**Consultation Response from KC,  
Conservation and Design****2021/93621 Land off, Fullwood Drive, Golcar, Huddersfield, HD7 4JH****Erection of 12 dwellings and associated works (Within a Conservation Area)****Date Responded: 28.03.2023****Responding Officer: Sebastian Pickles****Responding Ref:**

4 Front
1 : 100

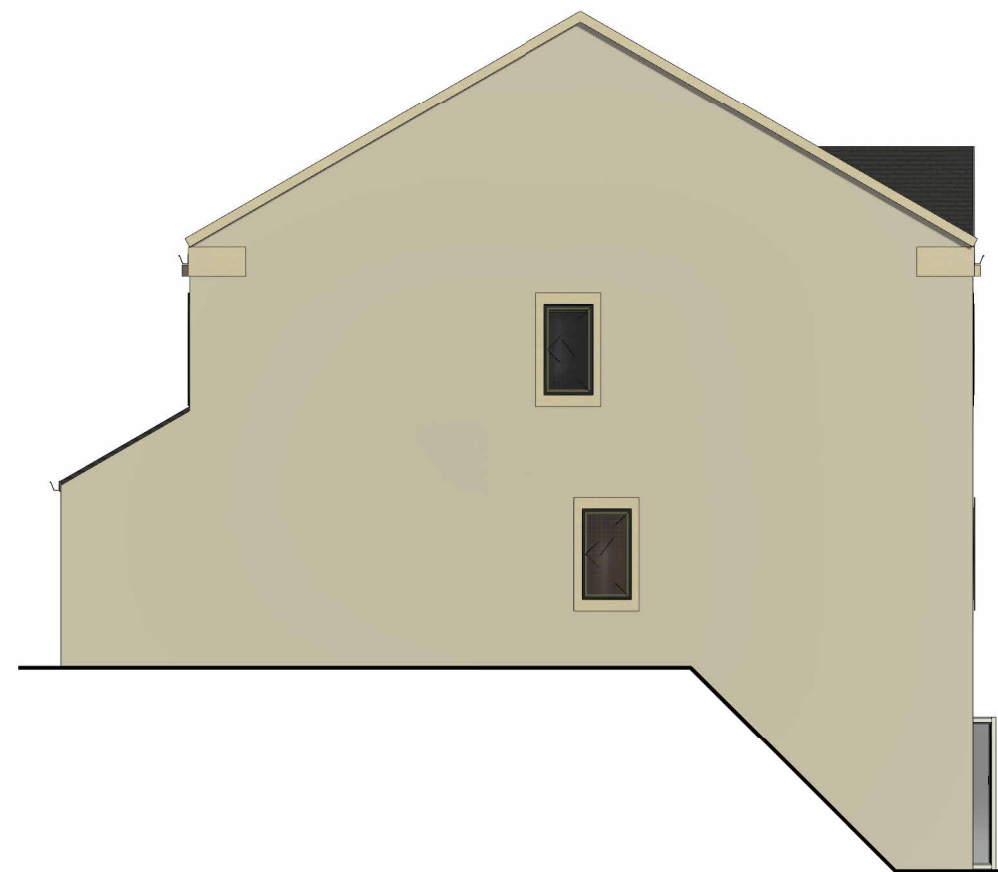
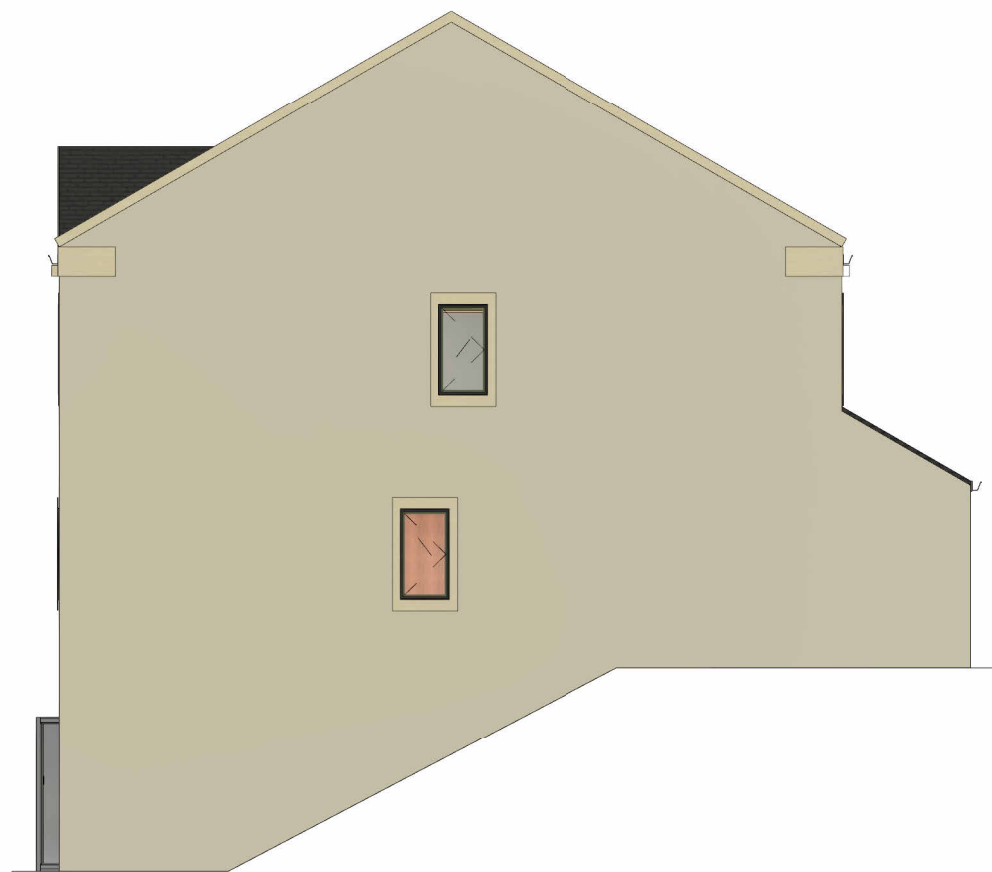
The amended plans have made positive changes to the overall design however, we do still have some concerns. While the overall form of the buildings is reasonable, the dwellings are lacking in architectural details. Conservation and Design consider details such as stone corbel gutter hangers should be included in the design. It could also be appropriate to include modest stone kneelers, which would add some additional architectural detail to roof lines.

We are also unconvinced by the details of the proposed windows and doors, which are only shown on the proposed elevation plans.

We consider that the windows and doors should be constructed in timber. We also consider that a more traditional door design should be incorporated. We are of the view that the garage doors should be constructed in timber and be centrally opening and would provide an improved visual appearance.

We also consider that the windows should be conditioned to be set back from the reveal by a minimum of 50mm, so as to ensure this gives some depth to the elevation.

The detail for proposed materials, especially the proposed stone is insufficient and should be conditioned for samples to be provided for approval. In consideration of the proposed construction of the dwellings, we would also for the stone to be constructed in regular courses and for all pointing to sit flush with the face of the stonework. We are also not convinced by the use of interlocking tiles as these do not reflect the character of the area.
